Subject: RE: AB/112/21/DOC (Canada Road)

Further comments following my consultation dated 27th September 2021 (item numbers referenced as previous) and their engineers response (enclosed);

Paul Cann
Principal Drainage Engineer
Engineering Services

TYPICAL CATCHPIT DETAIL (1200Ø)
(Scale 1:20)

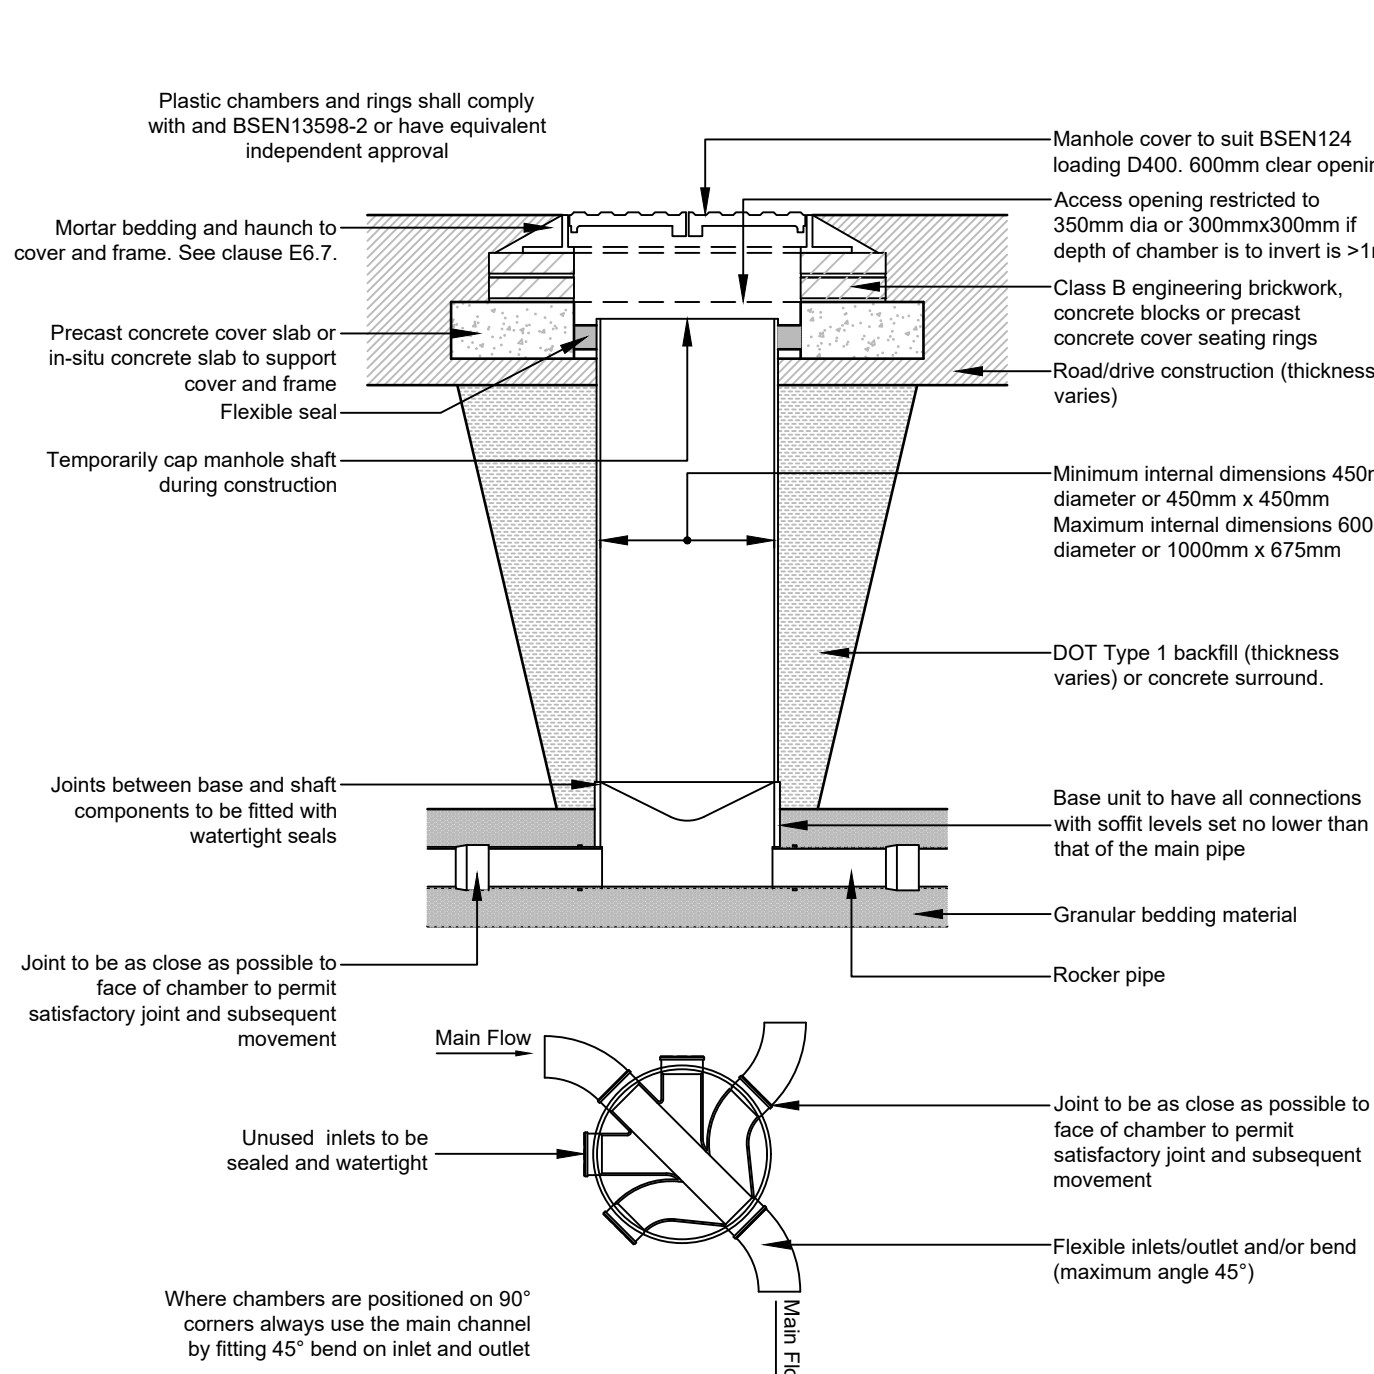
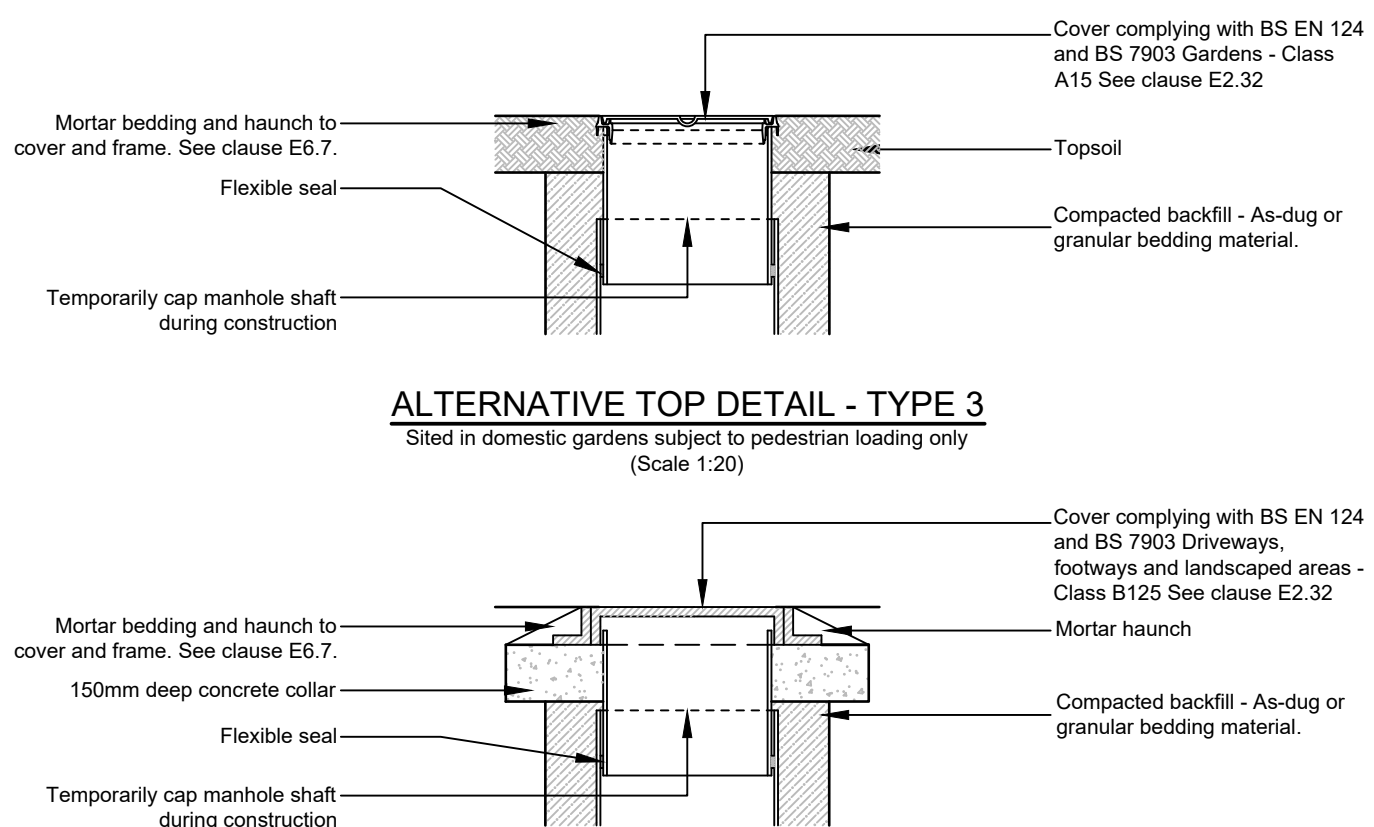
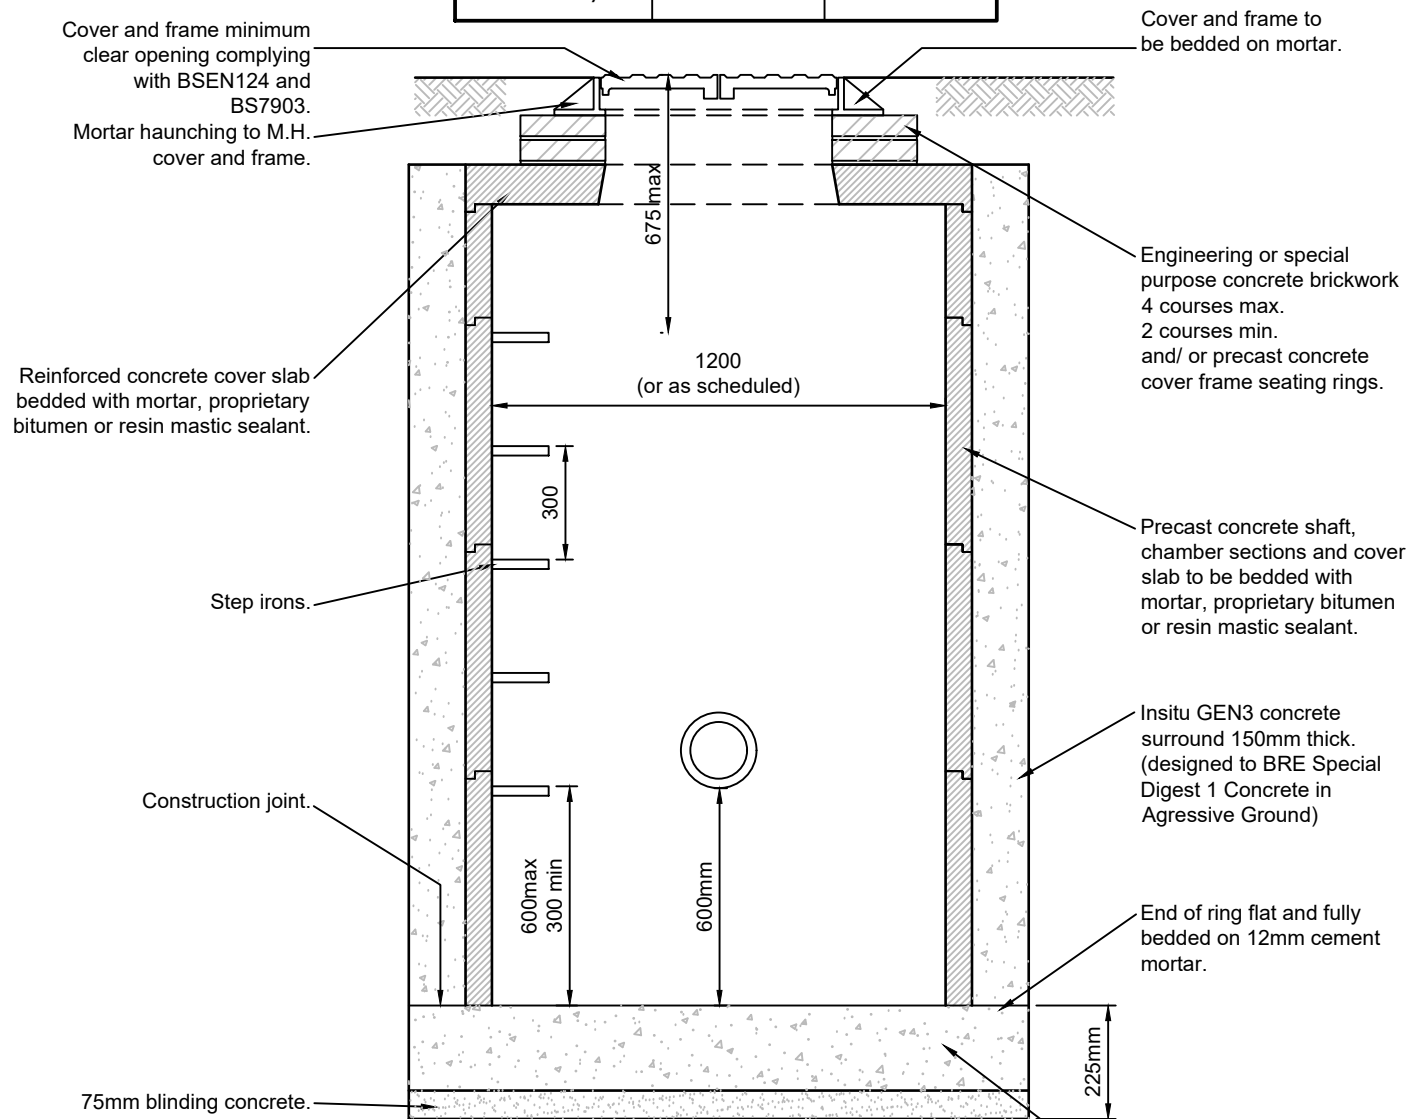
Item 1.4.1 – inlet/outfall section not relevant in this case? Desilting catchpits, gullies etc to be an annual event (minimum). Specifically mention the channel drain. Inspection items to be monthly for first 3 months, then annual. Include hydrobrake manufacturers maintenance regime. Include periodic inspection of pipework ie. CCTV survey, say every 5 years.

7. Ok.
8. Ok.
9.
 - a) Ok.
 - b) Please specifically mention ductile iron covers and frames including opening dimensions (for the contractors benefit).
 - c) Please specifically mention ductile iron covers and frames including opening dimensions (for the contractors benefit). If a formal overflow is to be provided then its level needs to be set above the predicted 1 in 100 year +40% flood level (indicate invert level). A better option may be to introduce a grated cover and use that as the overflow for events exceeding the 1 in 100 year + 40%, taking account of item 6 above. Specify sump dimensions based upon the hydrobrake manufacturers recommendations. Specify hydrobrake model. Indicate base thickness/ring surround thickness. Fully specify step rungs (not shown but required)/all concrete components including benching, rings, cover slab, mounting block, etc.
